## KITTITAS COUNTY COMMUNITY DEVELOPMENT SERVICES

March 28, 2019

**Subject: Palomino Fields Div 2 (LPF-19-00003) Final Long Plat – Staff Review and Request for Additional Information**

Surveyed by LMH Scale 1" = 300'
Drawn by Tml/FCS Sheet 1 of 5
Checked by FCS Project No. 18146

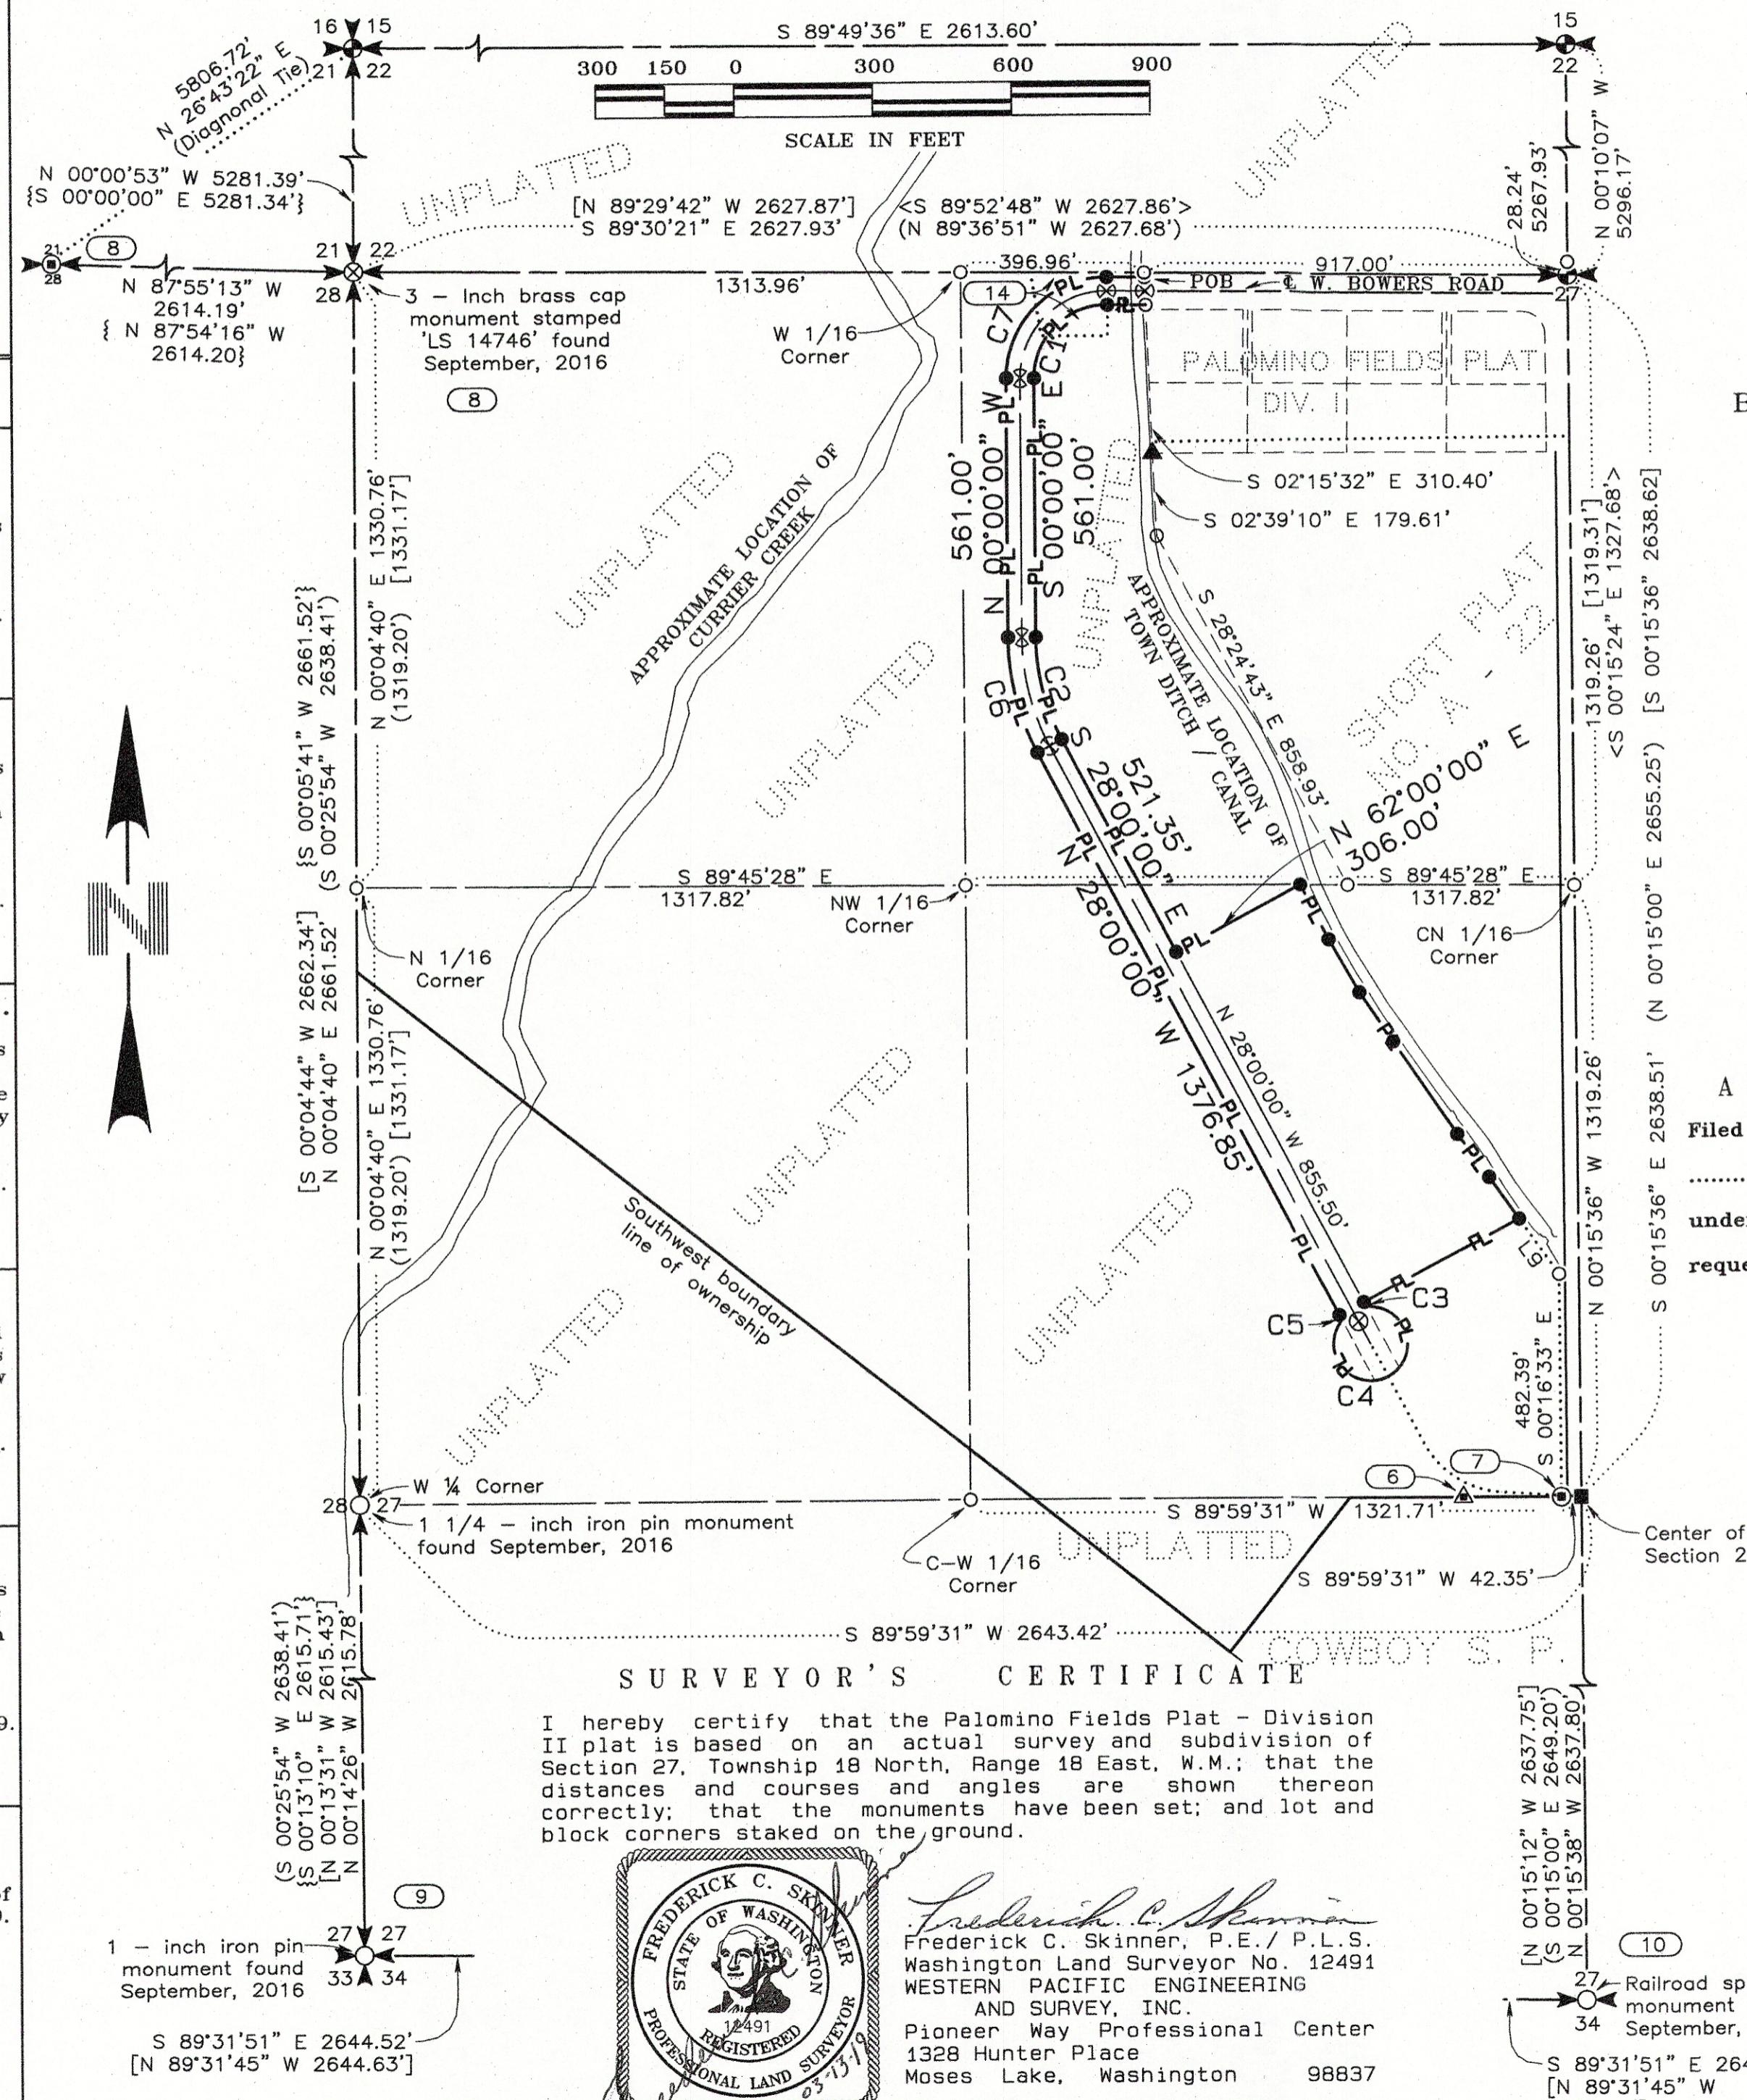
- An incorrect parcel number (471033) is listed in the Treasurer's and Assessor's signature box. This parcel was retired. The correct number is 491033.
- Parcels 11801 & 11802 should be listed in the Treasurer's box as well as the Assessor's box.
